**Subject:** Upper South Creek Advanced Water Recycling Centre (SSI-8609189) Response to Submissions Report and Upper South Creek Advanced Water Recycling Centre Submissions Report – project amendments

**Attachment A – EHG comments on the Upper South Creek Advanced Water Recycling Centre (SSI 8609189) Response to Submissions Report and Upper South Creek Advanced Water Recycling Centre Submissions Report – project amendments**

Figure 5-1 Biodiversity impacts from the Kemps Creek realignment

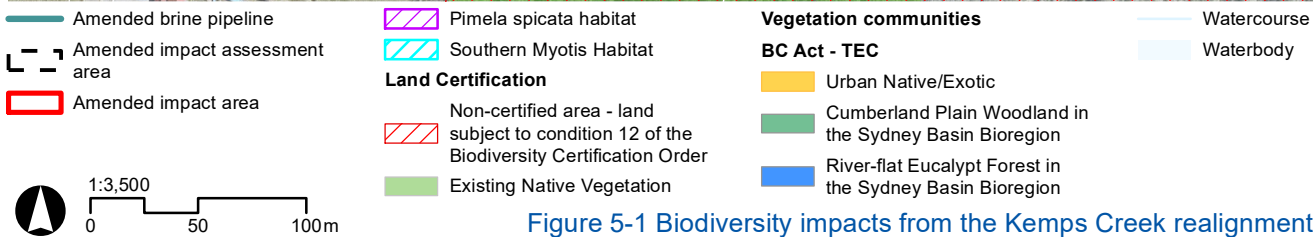
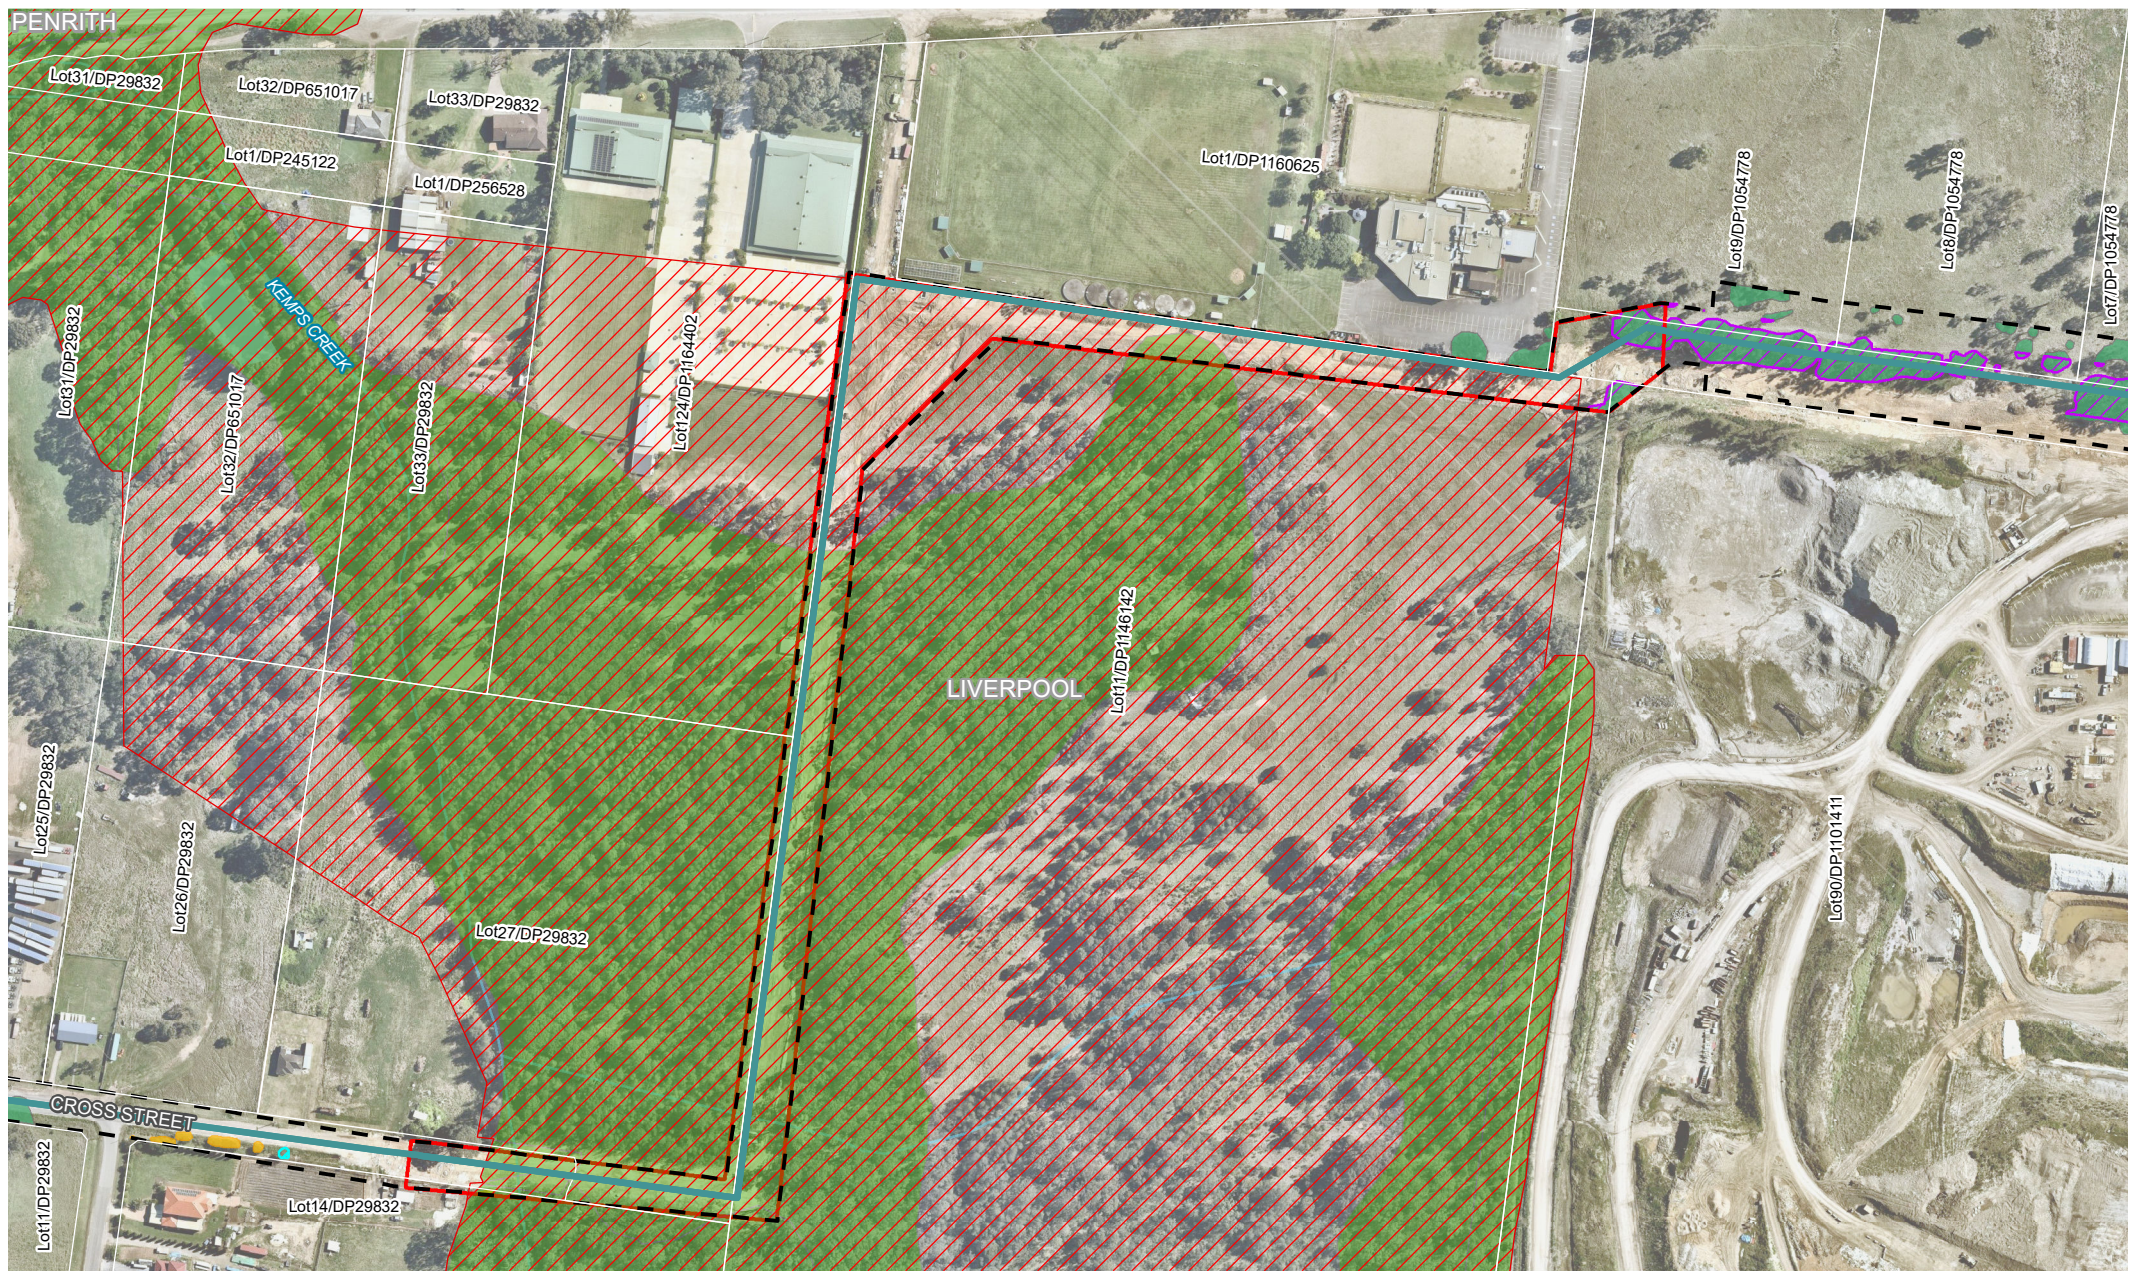
EHG previously also requested revised maps that depict ENV in addition to the RMB 12 red hatched area. In response, the Submission Report – project amendments includes a revised map that depicts ENV and red-hatched land for the amended alignment at Kemps Creek only. As outlined above, and as requested in its submission on the EIS, EHG seeks revised maps depicting the location of ENV (certified and non-certified), red and black hatched land and the proposed impacts from the entire development in the Growth Centres area.
